**KIRKLEES METROPOLITAN COUNCIL
INVESTMENT & REGENERATION SERVICE**

DELEGATED DECISION TO DETERMINE PLANNING APPLICATIONS

Reference No:	2026/62/90631/E
Site Address:	774, Bradford Road, Birstal, Batley, WF17 8NL
Description:	Erection of two storey and first floor extension to create dwelling forming annex accommodation associated with 774, Bradford Road, Birstal, Batley, WF17 8NL
Recommending Officer:	Jennifer Booth

DECISION - REFUSED

Drawing Title
**EXTN. TO SIDE
 PROPOSED DRAWINGS.**

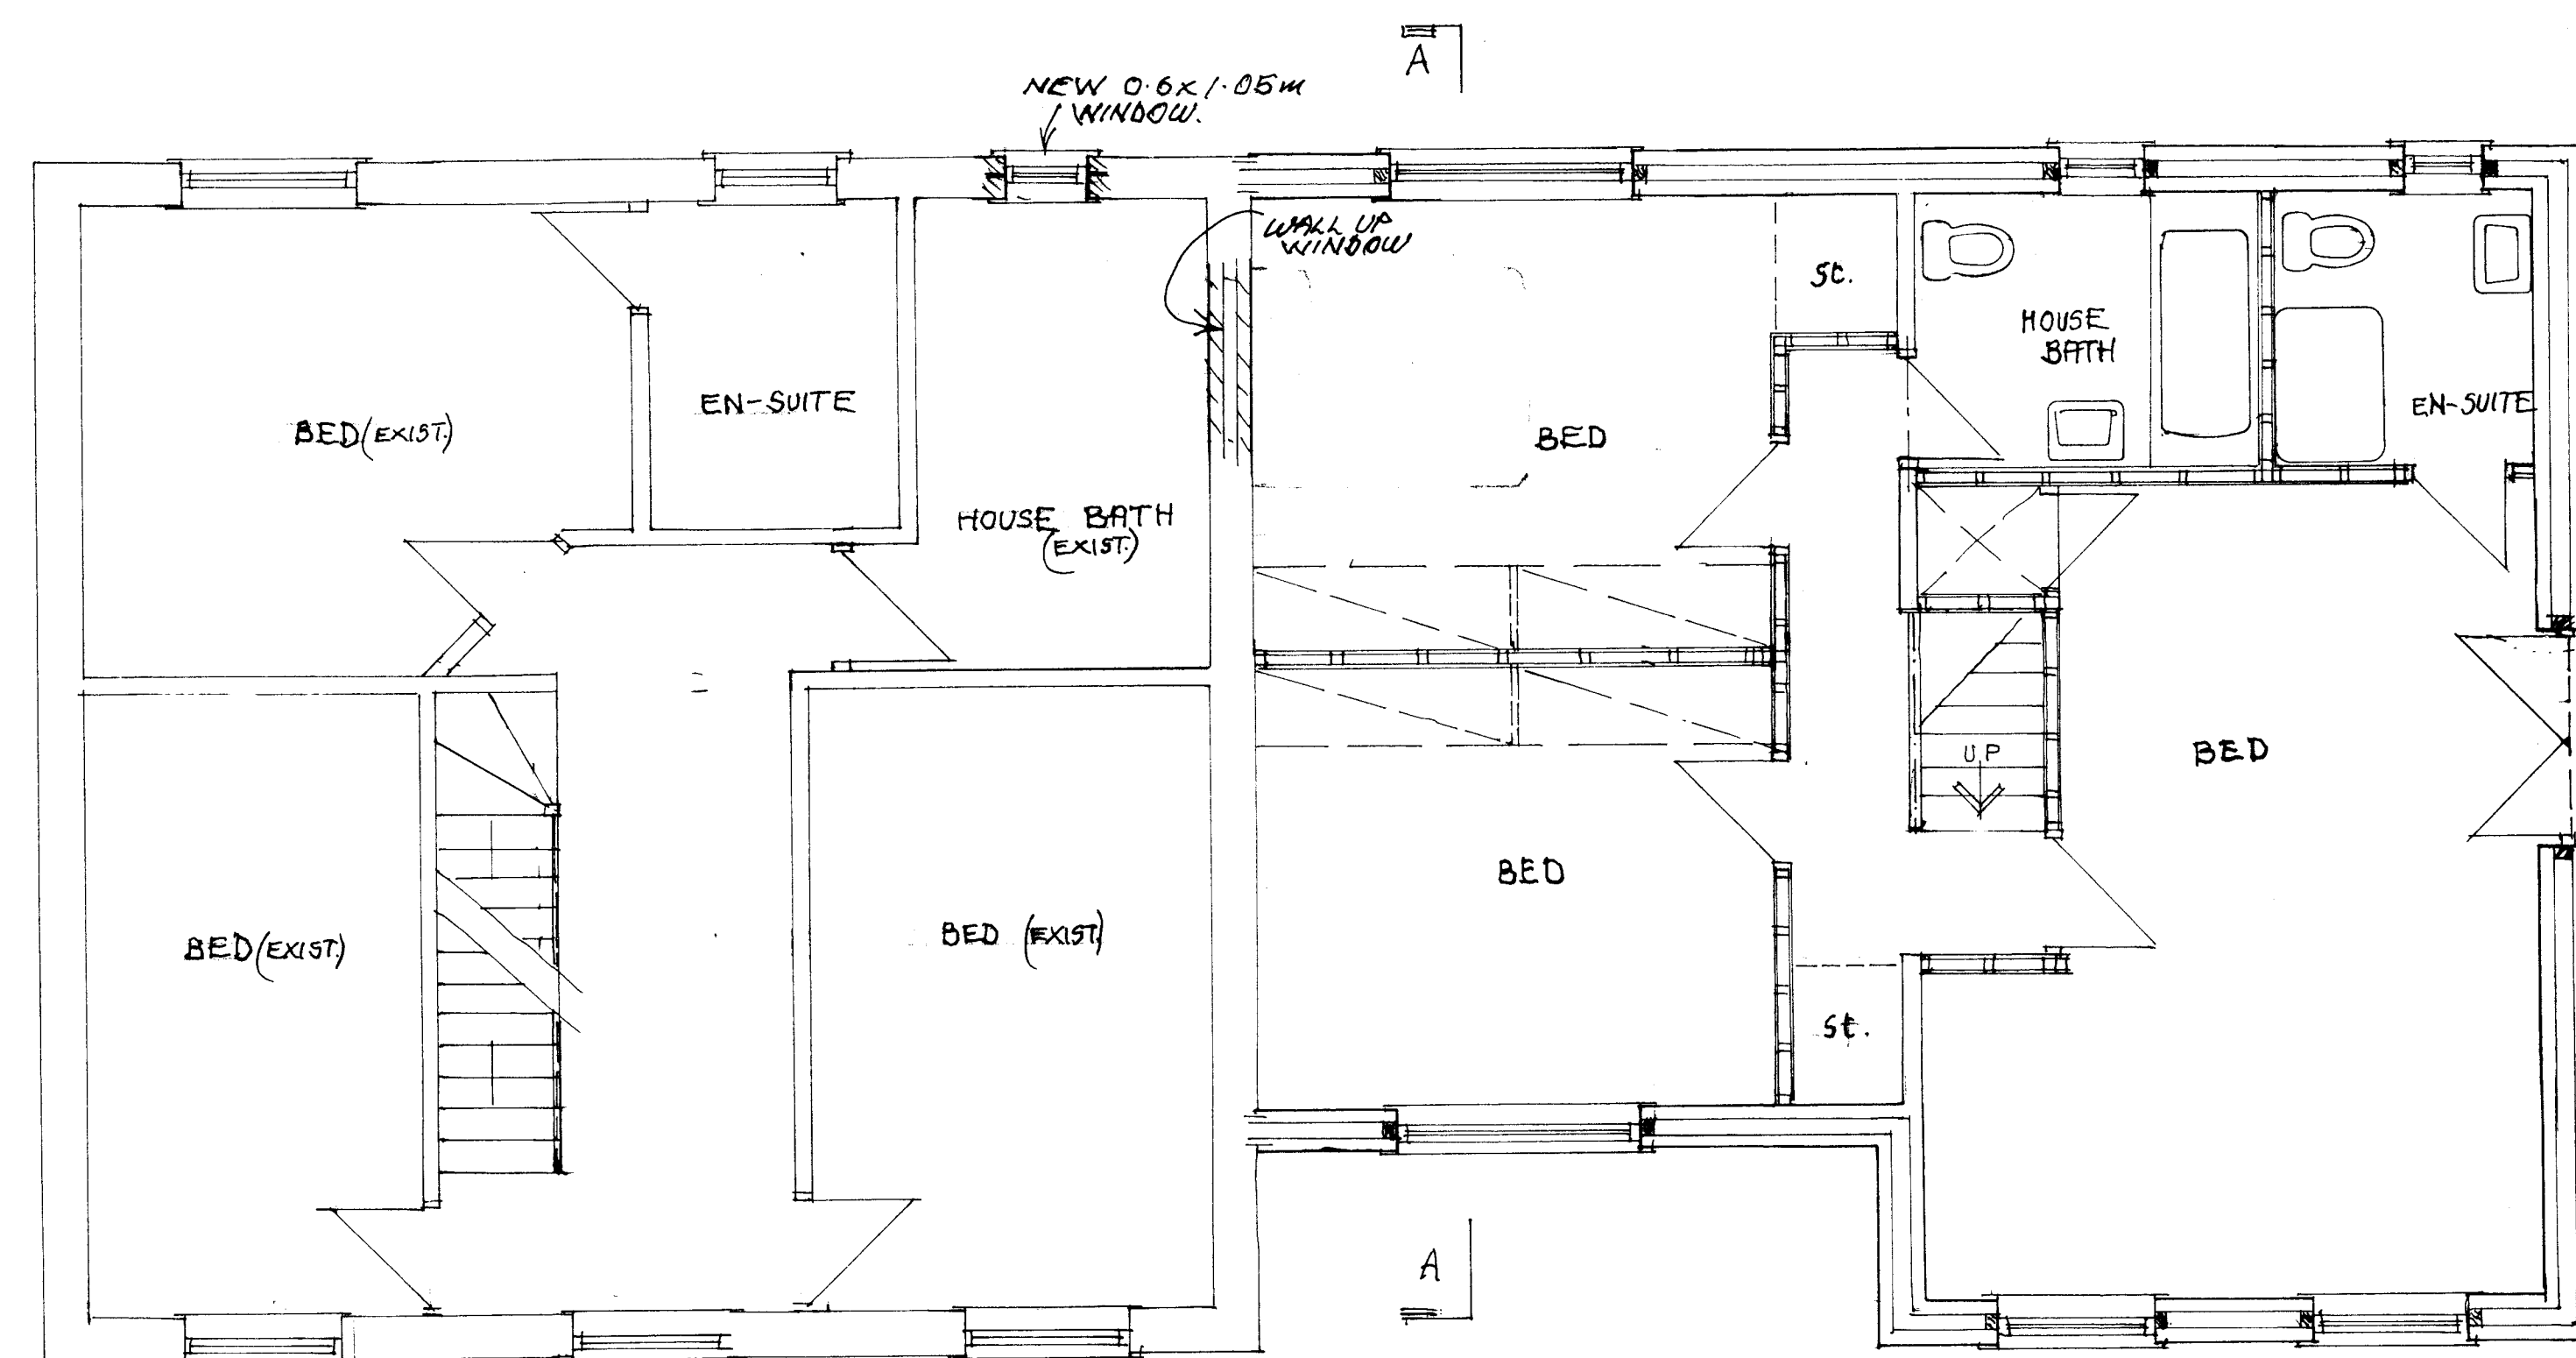
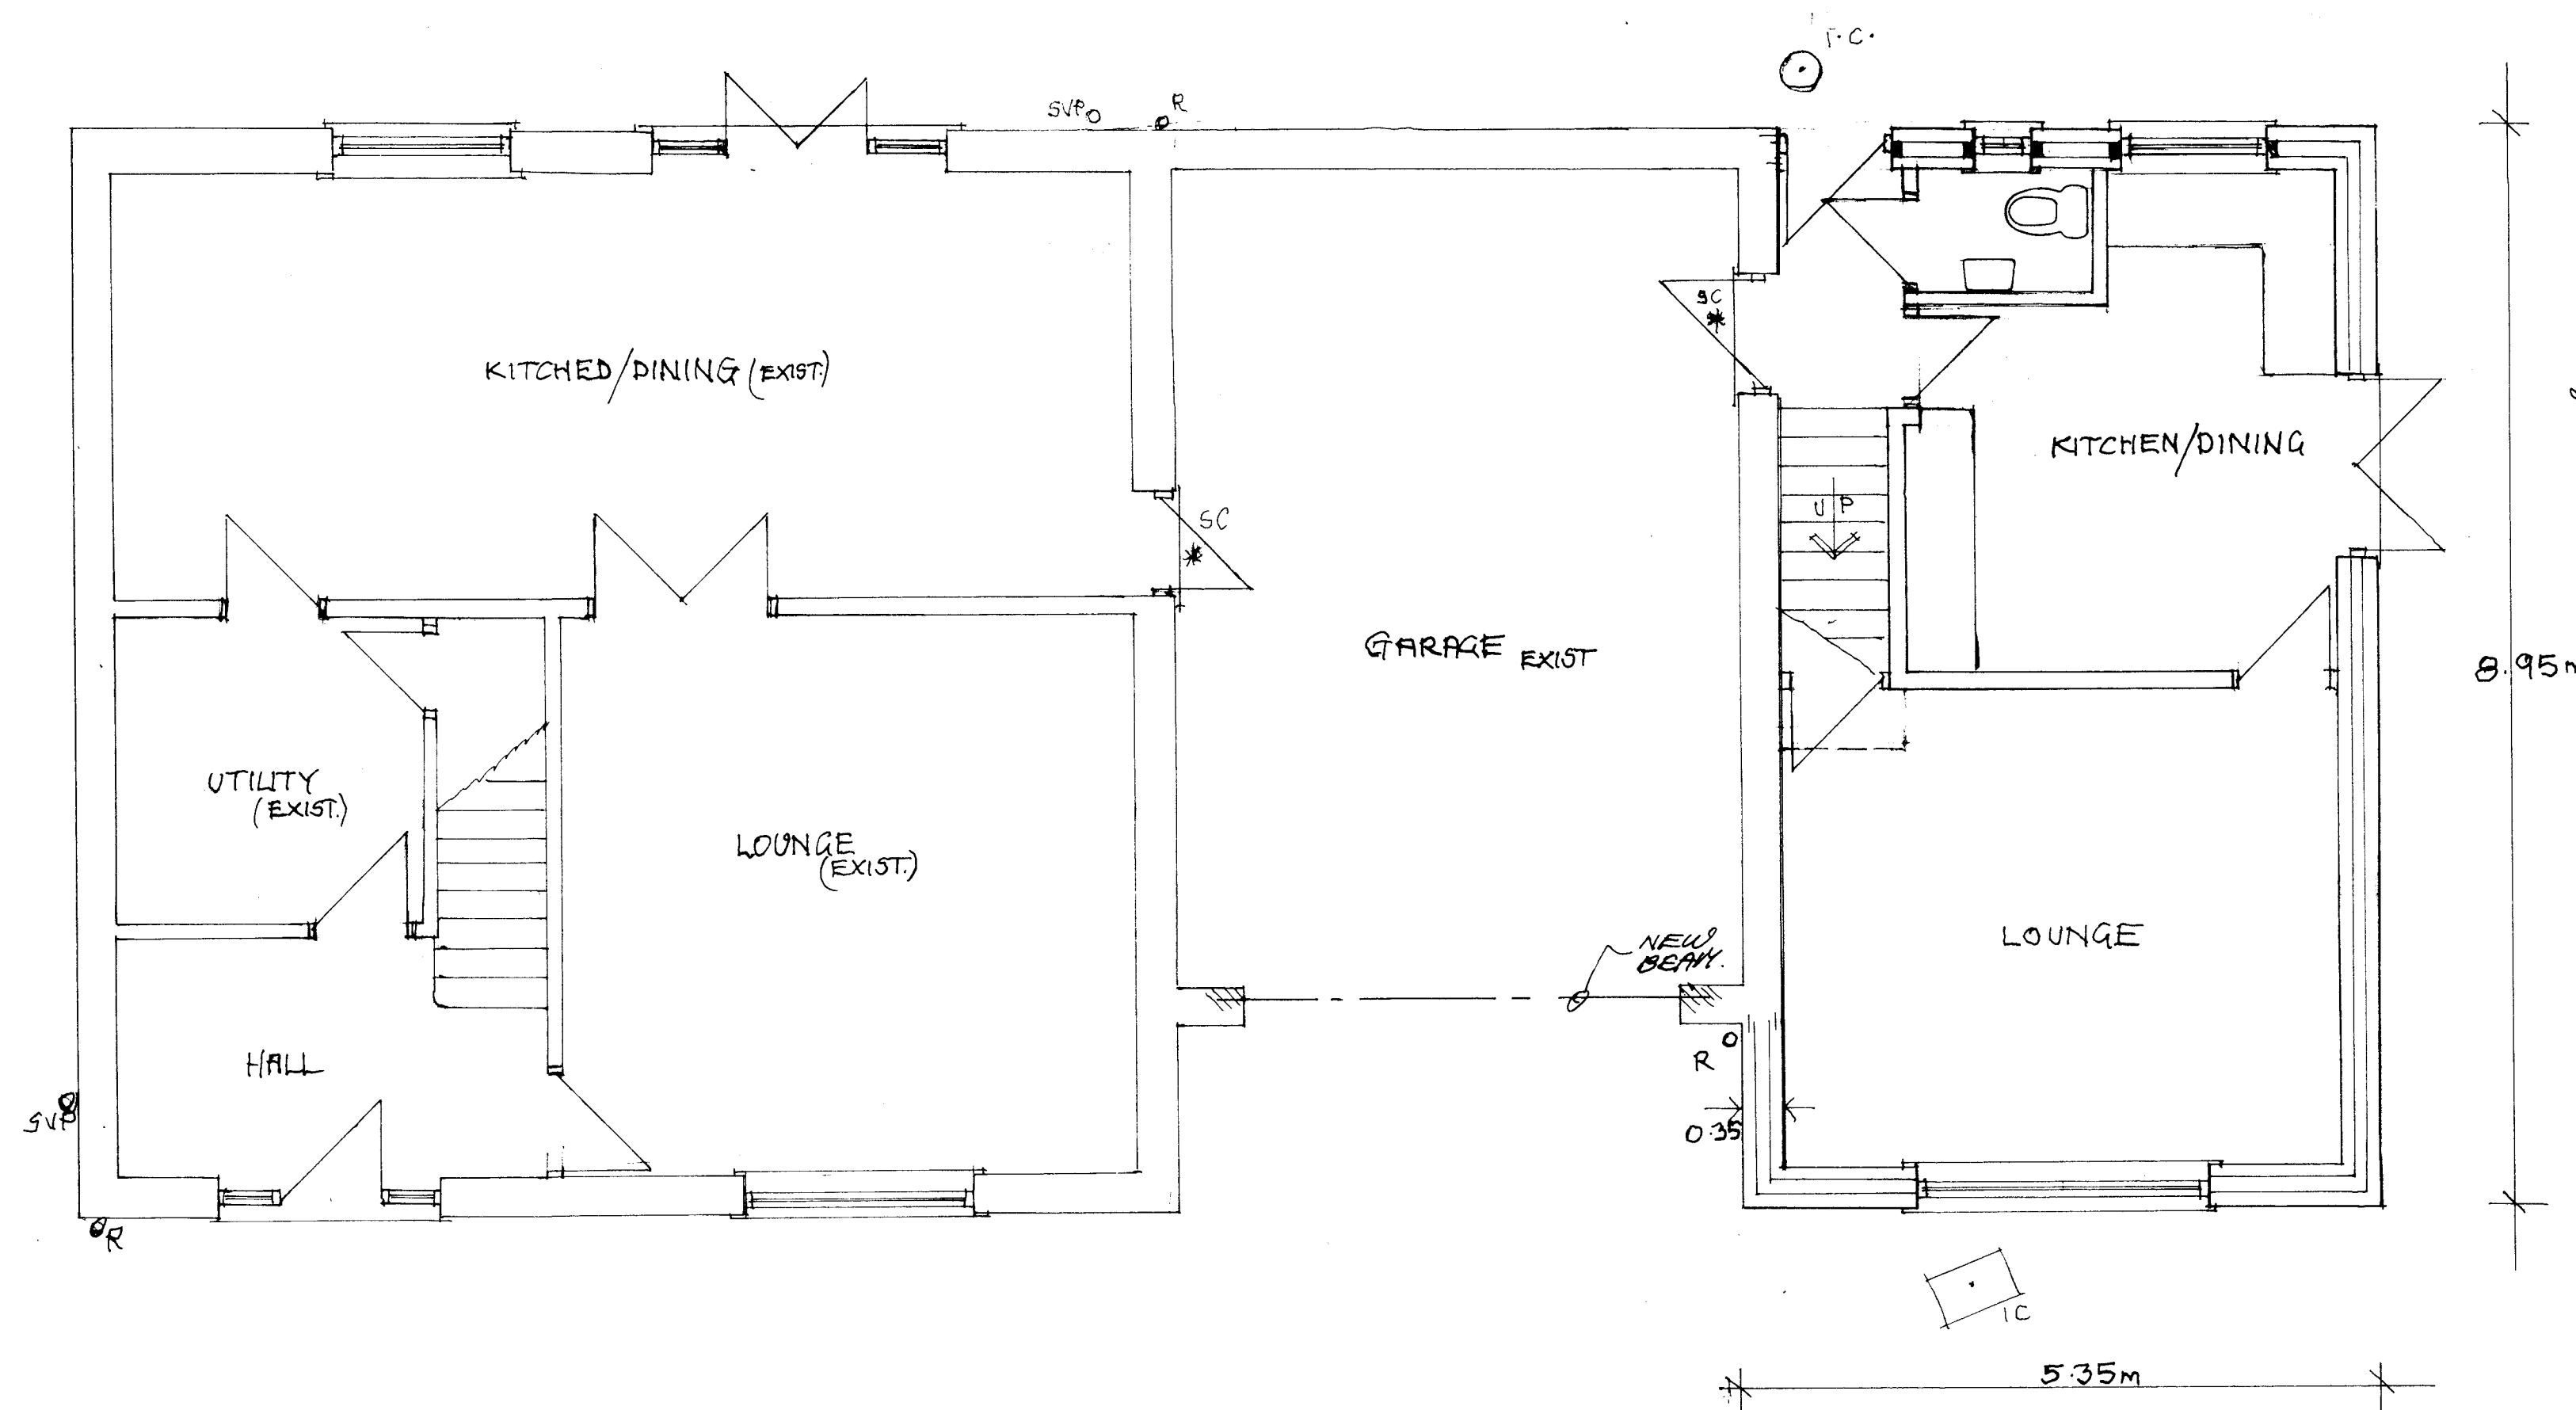
The plans show a living room, kitchen and wc on the ground floor of the extension adjoining the existing garage with a first floor over both the garage and the new ground floor accommodation with three bedrooms, one with an ensuite and a family bathroom.

The first floor extension over the garage and to the side would have an upper projection of 10m with the additional ground floor projecting 5.3m. The roof form would be a sloping pitch.

The annex is considered to be significantly larger than would be considered appropriate and acceptable and does not appear subordinate to the main dwelling thereby appearing as a separate dwelling unit.

In addition, it does not rely on any internal features of the main house, although it is acknowledged that external amenity space would be shared. Furthermore, the design of the annex is not considered to be complimentary to the style and character of the main property. Amended plans have not been requested.

The proposed annex is considered to be significantly larger than would reasonably be acceptable for such an addition and, as a result, fails to appear subordinate to the host dwelling contrary to the House Extensions & Alterations SPD. Its scale and independent nature are further emphasised by the lack of reliance on shared internal facilities within the main house,

functioning instead as a largely self-contained unit, notwithstanding the acknowledgement that external amenity space would be shared.

Furthermore, the design approach adopted for the annex is not considered to be sympathetic or complementary to the architectural style and character of the main dwelling, resulting in a form of development that appears incongruous within its context and harmful to the overall visual coherence of the site.

The proposed annex has been assessed against the Nationally Described Space Standards (NDSS). In order to meet the standards the accommodation for a three bedroom, 6 person unit should provide 102sqm. Measuring the annex it would exceed this standard at 111sqm. As the accommodation is ancillary, weight is afforded to this due to the flexible living provided in association with the main dwellinghouse with access to outdoor space. The bedrooms provide between 24.2sqm and 12.8sqm of space which is in compliance with the NDSS. These dimensions ensure an acceptable standard of internal amenity for future occupants, with adequate space for day-to-day living and circulation. There is also access to the shared amenity space with the main dwelling.

In terms of the impact on the amenity of the occupants of the host dwelling, it is noted that the annex would be adjoining the side elevation of the main house. The proposal would not significantly increase, loss of light, or other amenity impacts for the occupants of the main dwelling per se but would reduce the amenity space appearing overdeveloped.

The proposed annex, by virtue of its scale and massing, fails to appear as a subservient addition to the host dwelling and instead represents a form of development that is disproportionately large. Notwithstanding the sharing of external amenity space, the annex lacks ancillary connection to the main dwelling rather than dependent accommodation, undermining the ancillary form of accommodation. Furthermore, the design of the annex is not considered to be sympathetic or complementary to the architectural style and character of the main dwelling, resulting in an incongruous form of development that is detrimental to the character and appearance of the site and surrounding area. To permit the proposals would be contrary LP24 of the Kirklees Local Plan, KDP1 & KDP2 of the House Extensions & Alterations SPD and Chapter 12 of the National Planning Policy Framework.
